Settlers View Subdivision  
Transportation Memorandum  
(LSC #164720)

Add PCD Project No's: P-17-004 and SP-17-006

RE: Settlers View Subdivision  
El Paso County, CO  
Transportation Memorandum  
LSC #164720

SETTLERS VIEW SUBDIVISION  
Preliminary Plat  
El Paso County, Colorado

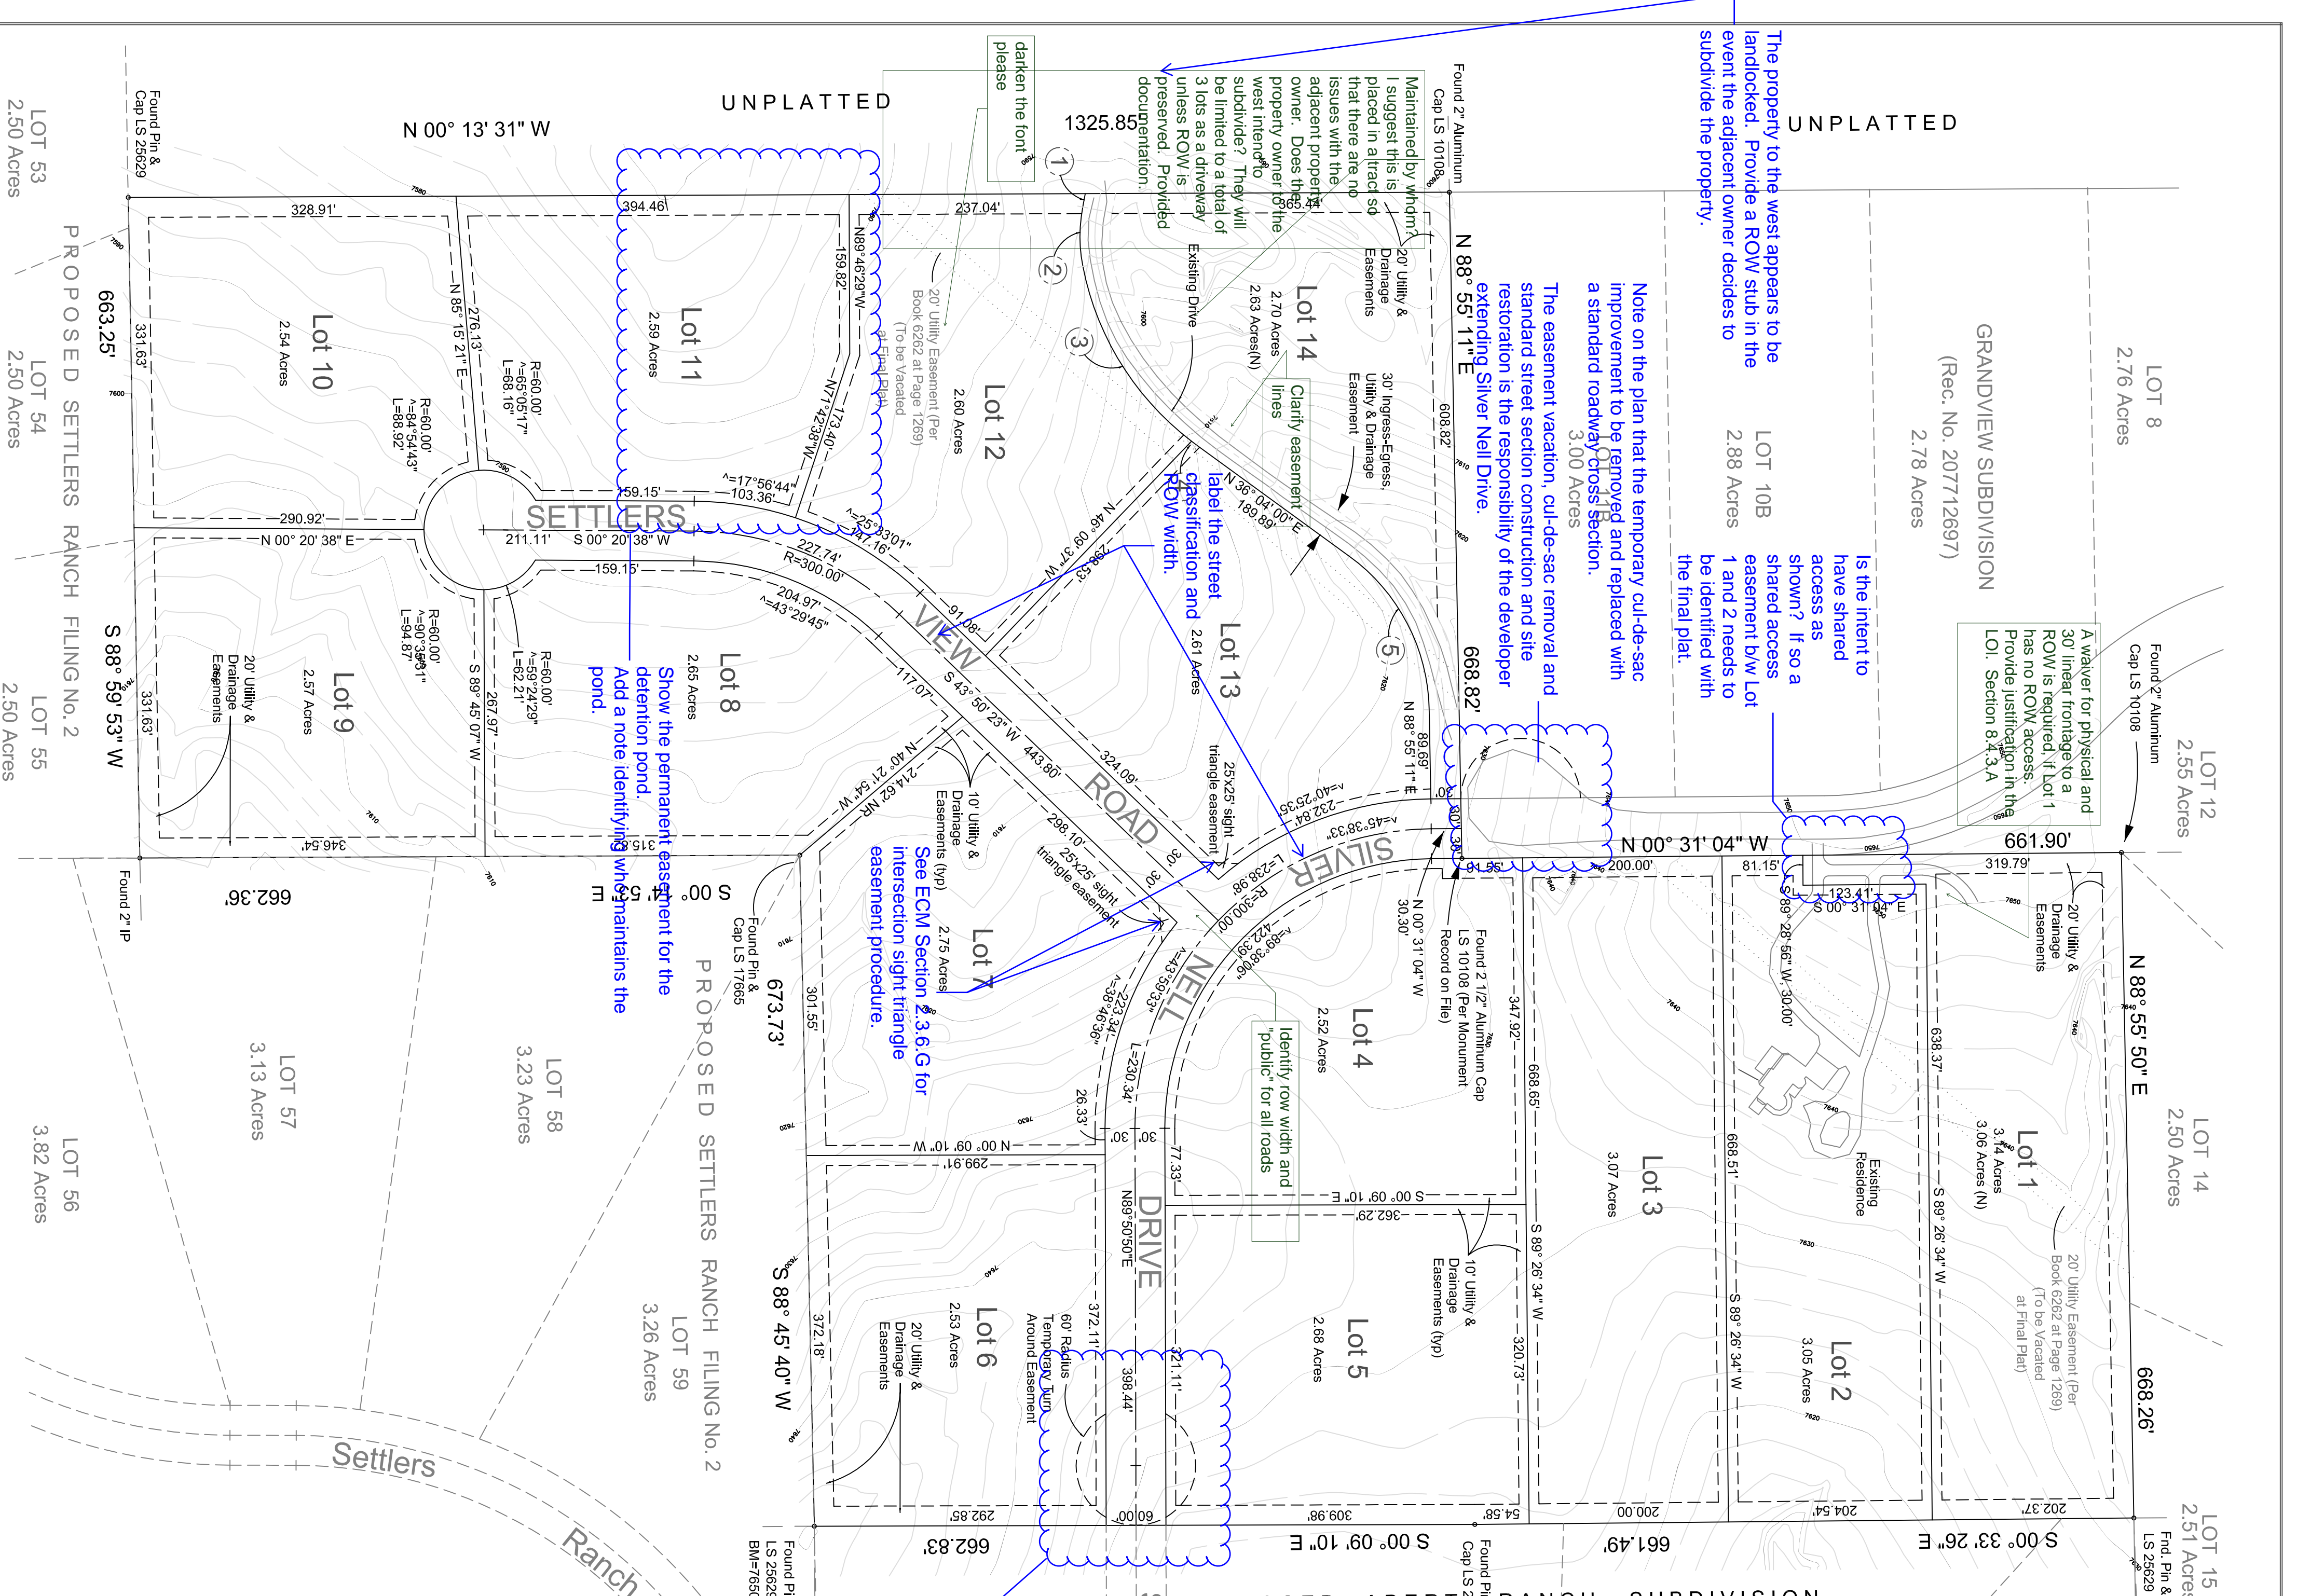
Submit a deviation request from the maximum length criteria for a cul-de-sac .  
The deviation must include a written endorsement from the Fire District.
